From:
Sent: 04 September 2025 18:19
To: DC Admin
Subject: Objection to planning application 2025/92135

**OBJECTION TO PLANNING APPLICATION 2025/92135
2 HOLLYBANK AVENUE, BATLEY, WF17 0AQ**

PROJECT	2 Hollybank Avenue, WF17 0AQ
SHEET	Proposed Plans

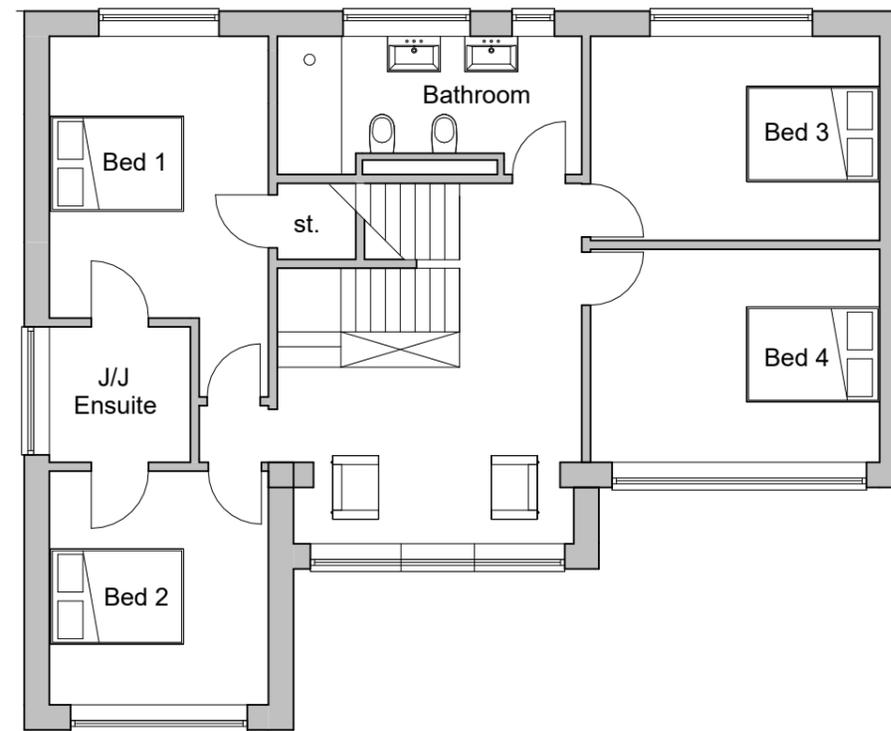
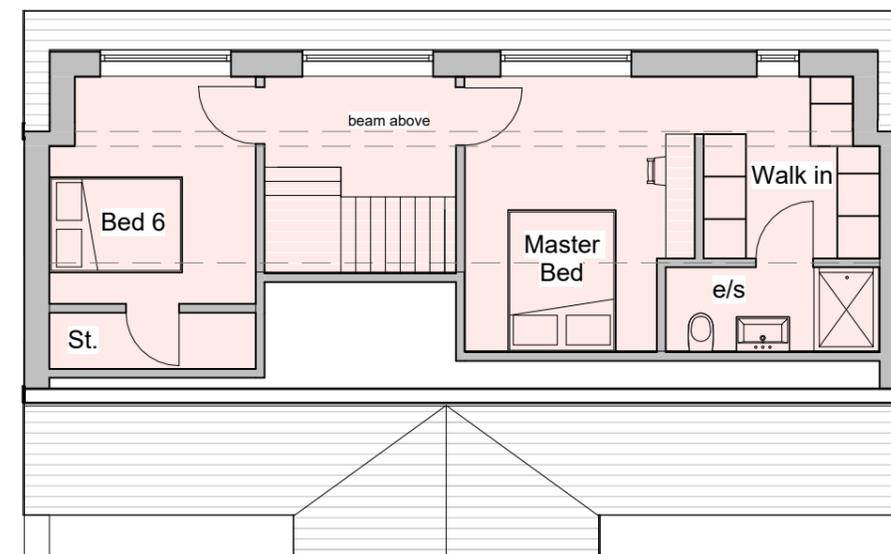
>
> The planning application proposes a near doubling of number 2's footprint as well as an increase in height with additional second floor accommodation. The precise dimensions are not clear from the plan but it appears the building will be at least 2 maybe 3 feet higher (6 courses of bricks), possibly more when a new roof is added.

>
> The plans would have a devastating impact on us. The 3 metre wall adjoining our rear garden, built right on our border, would block out sunshine and light and windows and the new, dormer-windowed second storey would overlook our garden and result in loss of privacy. We enjoy the use of our rear garden, especially on sunny days - this enjoyment would be completely compromised. Our garden would feel more like a prison yard bordered by a 3 metre wall.

>
> It is not clear from the plans how drainage from the roof of the ground floor extension would work. Would water cascade from the roof into our garden? Presumably there would be guttering, some of which would need to be on the ground floor elevation bordering our garden. Where would the downpipes be positioned and where would they drain away? How would the guttering be cleaned without access (the large deciduous trees which are not mentioned in the application on the adjoining property discard a huge quantity of leaves)? This

Also the main sewage pipe for Hollybank Avenue runs through the middle of our back garden and into 2 Hollybank Avenue where it makes a right angle back into the avenue road. This sewage pipe regularly gets blocked and needs access to clear. The rear extension is proposed to be built directly over this main sewage pipe.

SHEET  
**Proposed Elevations**

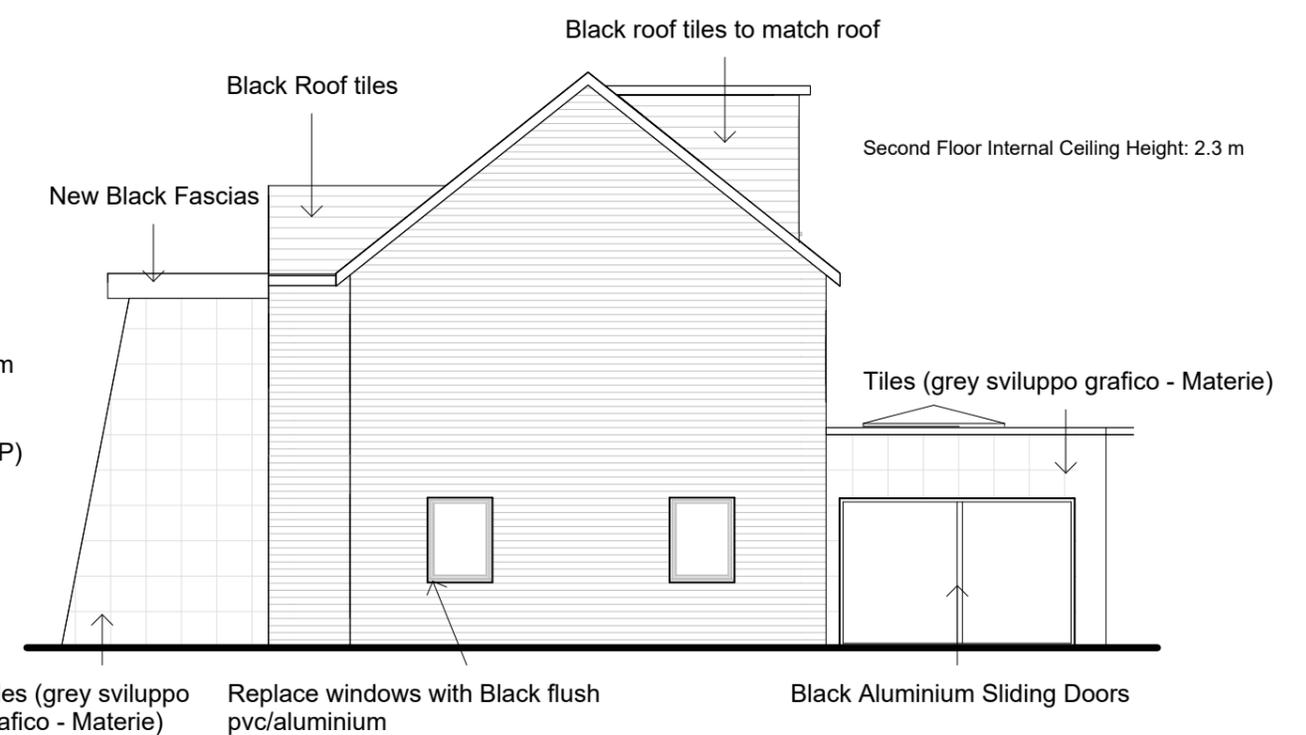
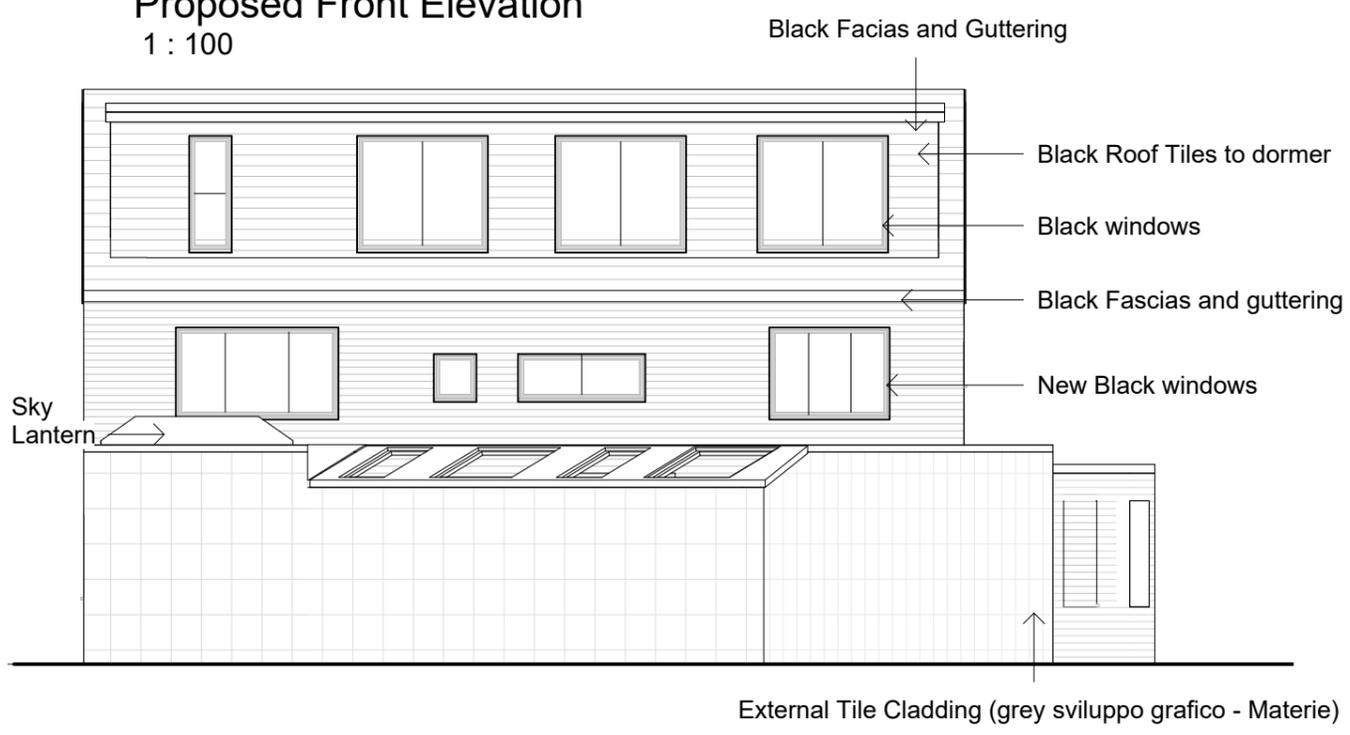
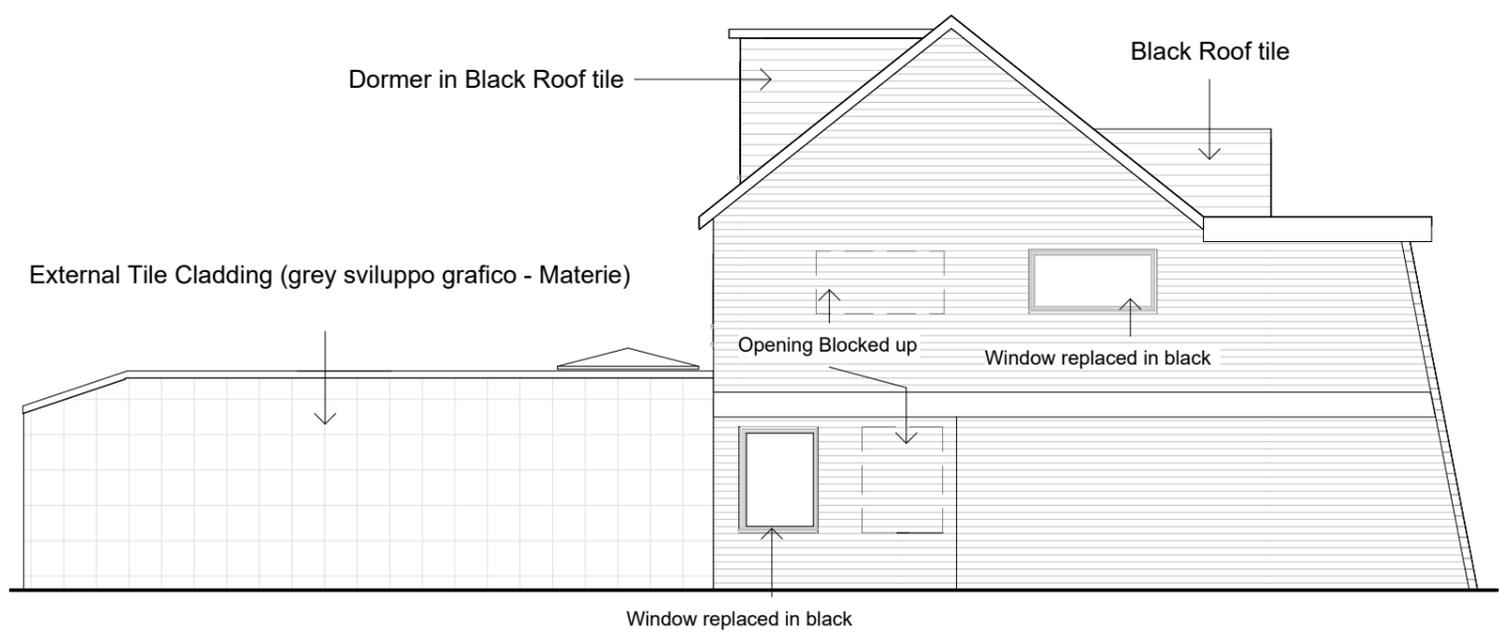
>
> Clearly, such expansion is not in keeping with the remainder of the houses on Hollybank Avenue and there would be a negative impact on the street scene and with a 6 bedroom house being planned there will be implications for parking in the future.
